HARNETT COUNTY

DEPARTMENT OF PUBLIC HEALTH

Applicant: John & Angela Kokoszka
Rt. 11 Box 170
Sanford, NC 27330

Re: Status of Improvement Permit Application

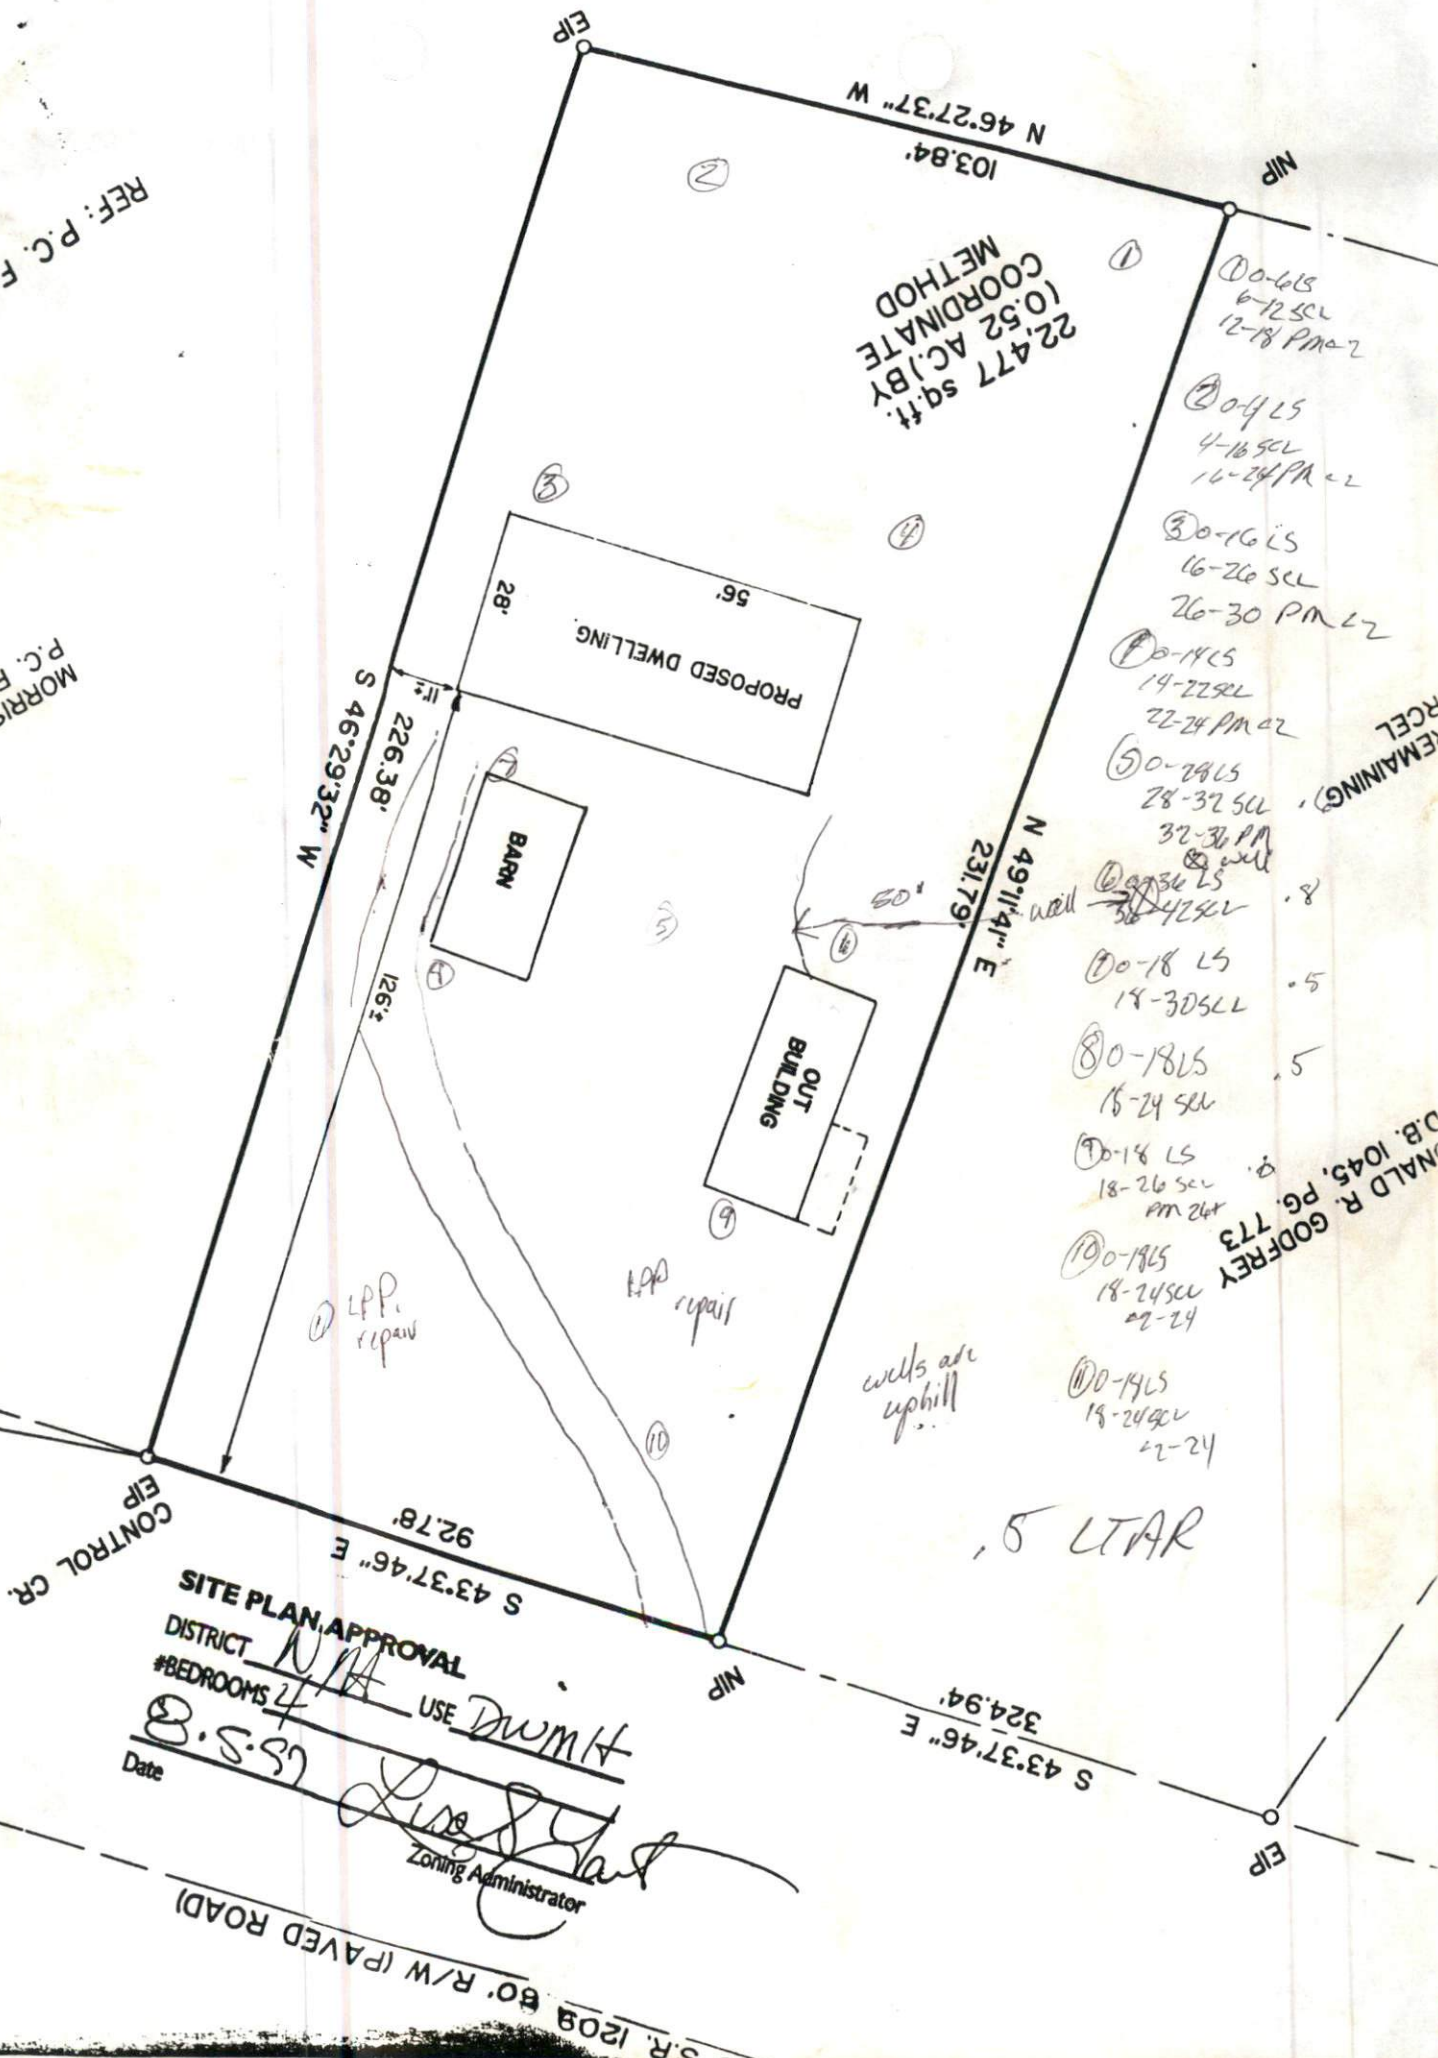
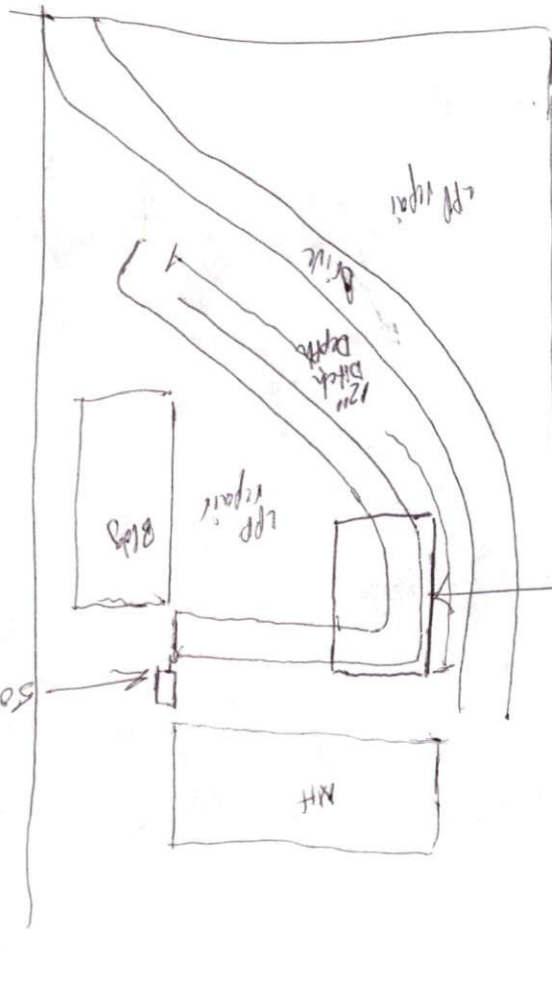
- ☐ 1. Topography and/or landscape position. (.1940)
- ☐ 2. Soil characteristics-texture, structure, mineralogy. (.1941)
- ☐ 3. Soil wetness condition. (.1942)
- ☒ 4. Soil depth. (.1943) Parent material at 18" to 24"
- ☐ 5. Restrictive horizons. (.1944)
- ☒ 6. Available space. (.1945)
- ☐ 7. Other.

MAY be suitable
for LPP or fill
SYSTEM
